17th May 2021

Application No: AB/29/21/L
Site Address: 78 Maltravers Street Arundel BN18 9DS
Description of works: Listed building consent to replace windows 2 No. front and 1 No. rear windows.
Replicas of existing design, with 4-4-4 ultra lite glazing, 3 No. box frames with sash.

OWPC36287

Drawing
Typical detailed elevation
and section

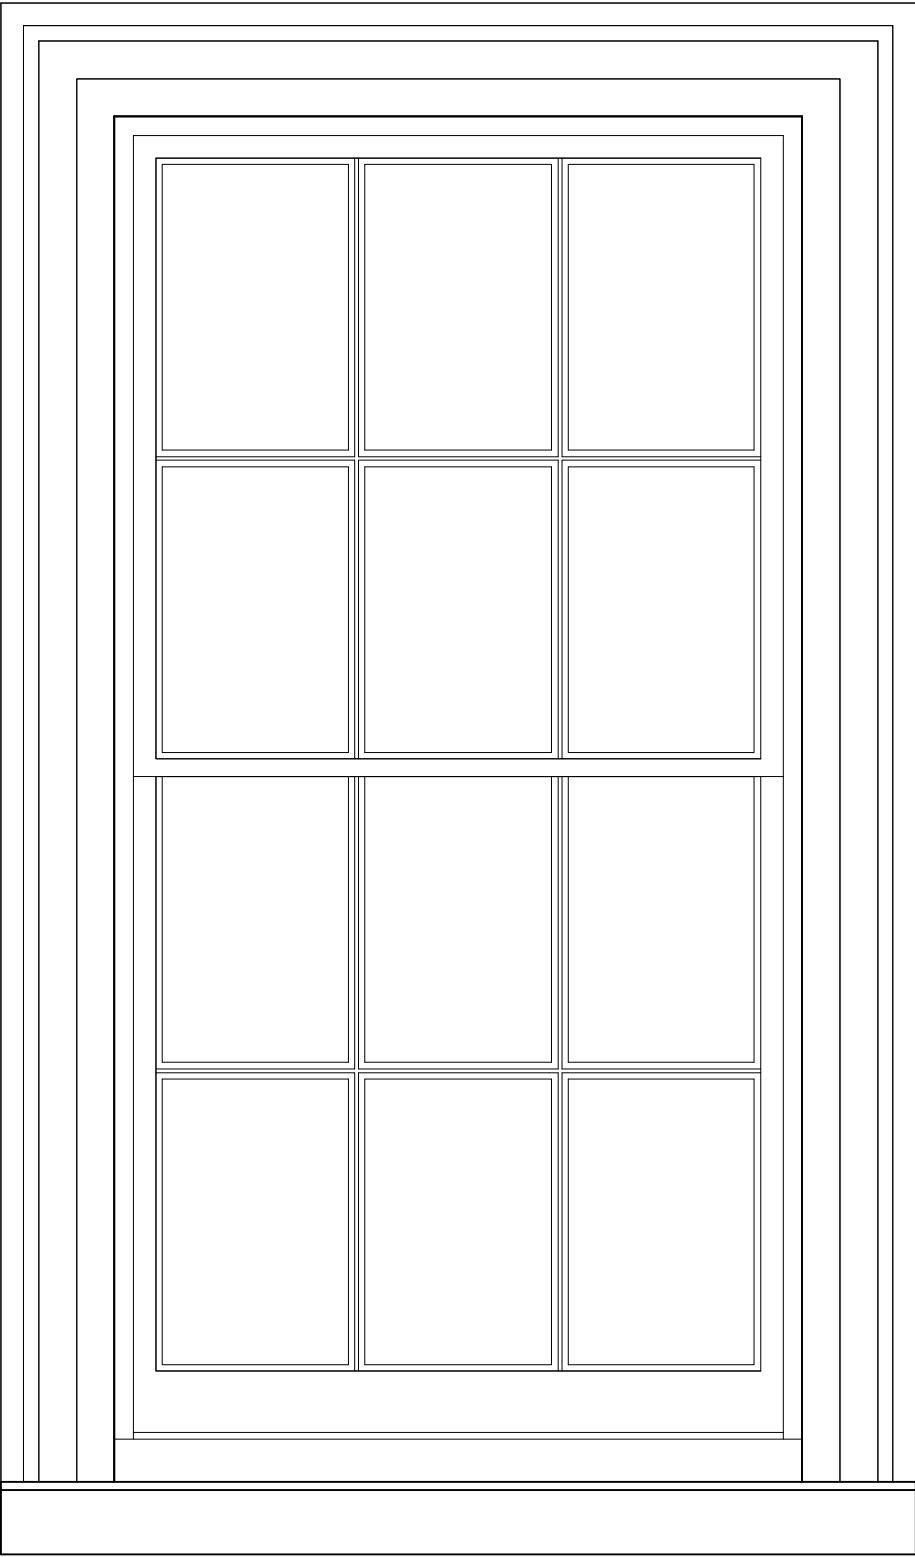
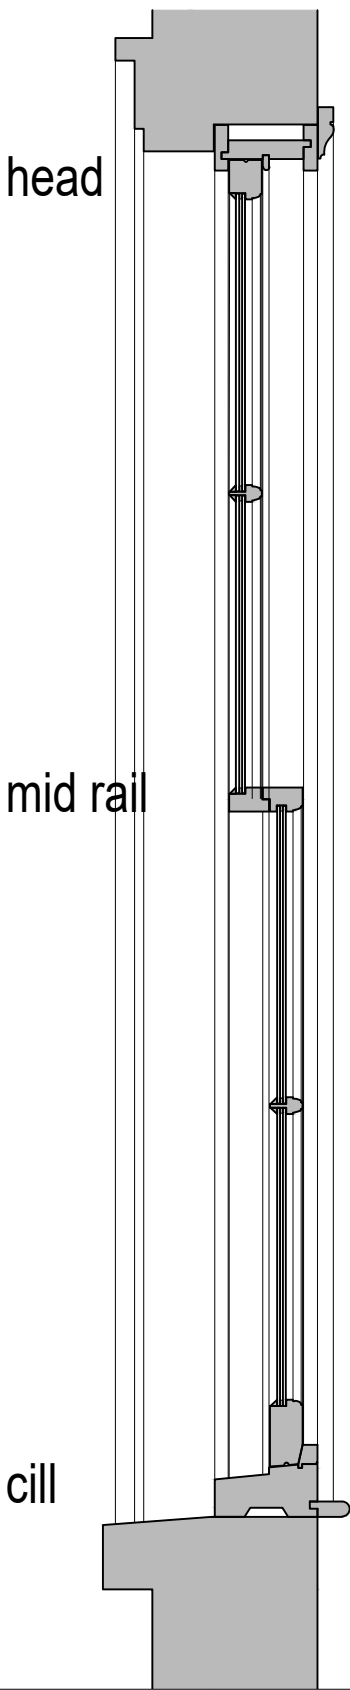
It is assumed that the intention would be to paint the new timber joinery white but that does not seem to appear in the method and materials statement.

Since historic fabric and construction is involved, repair will always be the preference instead of complete replacement and evidence needs to be submitted to indicate whether or not the windows have disintegrated beyond the possibility of reasonable or satisfactory repair. There is ample advice given by Historic England concerning the various methods of improving thermal insulation in historic buildings while still retaining existing single glazed windows which can be upgraded without recourse to double glazing. Detailed advice is also readily available concerning the appropriate repair of traditional windows.

The narrowness and fineness of the glazing bars to the multi-paned windows in the group is also an essential part of their appearance and significance, reflecting also the architectural period of their construction. A detailed drawing should be submitted showing a large scale cross section and elevation of an existing and a proposed glazing bar. A possible problem is that even with ultra-thin double glazed panes the extra weight is likely to require thicker glazing bars. Even if not, then paintwork would need to be extended to conceal the edge seals. These aspects are addressed in images 118-120 on page 56 of the Historic England advice publication mentioned above. Even a difference of a few millimetres would be noticeable and detract from the significance of the building and the group which contains prominent, repetitive, sash windows of
